WELWYN HATFIELD COUNCIL – DEVELOPMENT CONTROL
DELEGATED REPORT

APPLICATION No:	W6/2013/729/EM
APPLICATION Site:	8 Rooks Hill, WGC

DESCRIPTION OF PROPOSAL: Erection of part single and part two storey rear extension and new window to flank elevation

Drg.No: AT442-06

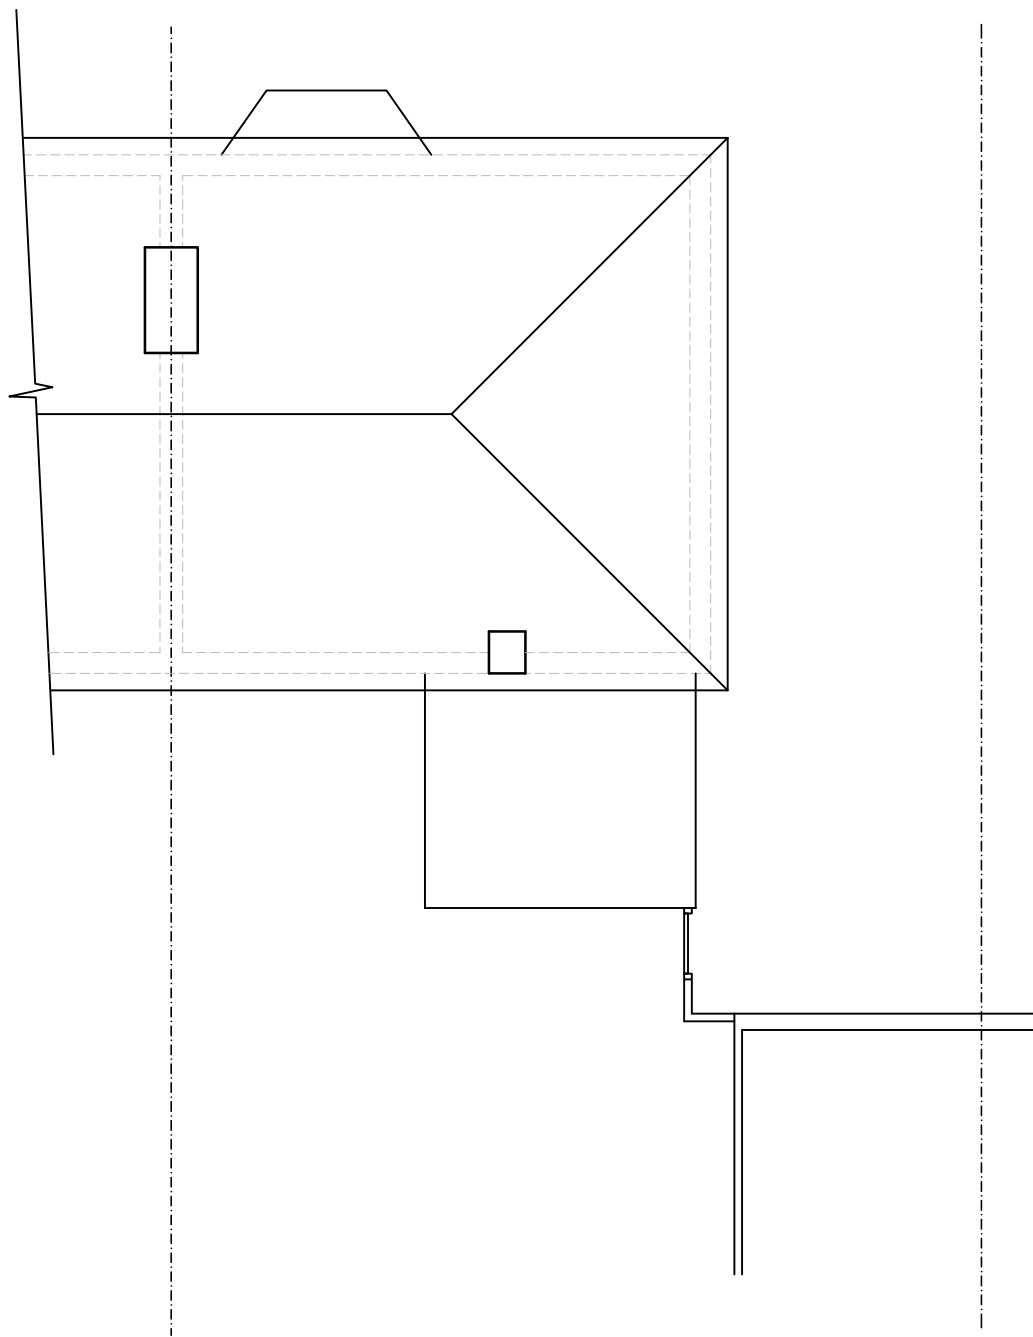
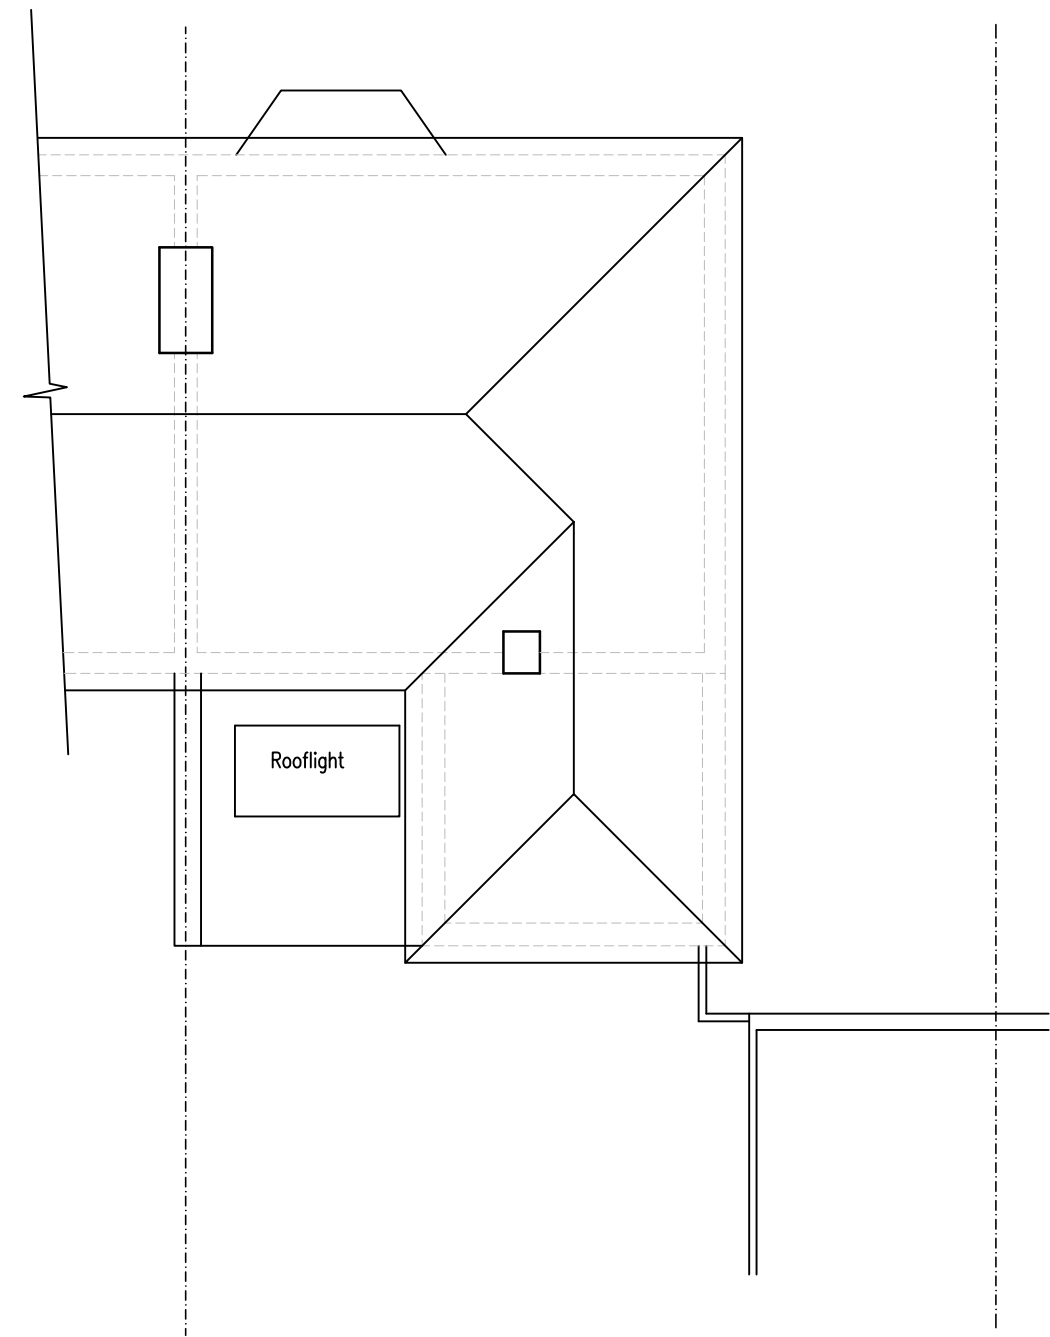
The proposal is to extend the property to the rear to a depth of 3.6m to create a kitchen and lounge area. This will extend to the full width of the existing property and will be flush with the existing side wall of the dwelling. Above part of the single storey extension will be a first floor extension creating a larger bedroom which will be to the same depth and will have a width of approximately 4m. Above this a flat roof is proposed over the single storey rear extension and a hipped pitch roof over the first floor which will be flush with the current hip of the main roof with a ridgeline which is stepped down.

Drg.No: AT442-05

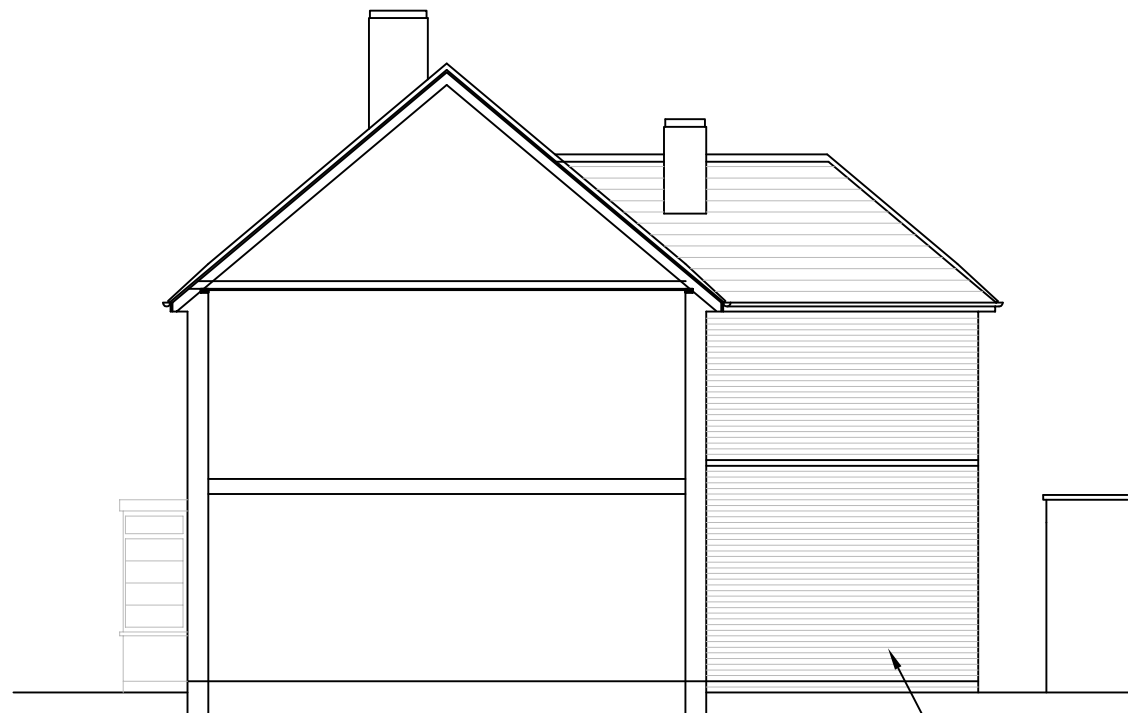
These changes which relate to the rear of the property are considered to appear subordinate in scale to the original dwelling and will reflect the existing character with window fenestration of a similar style. Subject to the use of matching materials, the proposed extension will be in-keeping with the character of the existing dwelling and will reflect the wider character of the surrounding area, which also include similar extensions to the same type of property at Nos. 2 & 4 Rooks Hill.

In regards to No.6, a proposed party wall is proposed at ground floor level. The depth of this new flank wall and height are considered not to appear overly dominant or over bearing to this neighbour as the scale of this wall is reasonable in this location. No side windows are proposed and so there will be no direct overlooking. Although there will be some overshadowing from the new flank wall during the first part of the day, this will not be so significant as to be harmful to the residential amenity of No.6.

At first floor level the proposed extension is set back sufficiently from the common boundary with this neighbour to ensure that it will not harm the outlook of this

neighbour's rear first floor window in terms of sunlight/daylight or from the extension appearing over dominant.

There is a new side window proposed at first floor level to serve the enlarged bedroom which is shown obscure glazed and non-opening below 1.8m for floor level. A planning condition to ensure this requirement is reasonable to avoid any potential overlooking to this adjoining neighbour.

7. EM03
8. The proposed first floor side to the new bedroom of the proposed building shall be glazed with obscured glass and shall be fixed so as to be incapable of being opened below a height of 1.8 metres above floor level, and shall be retained in that form thereafter.
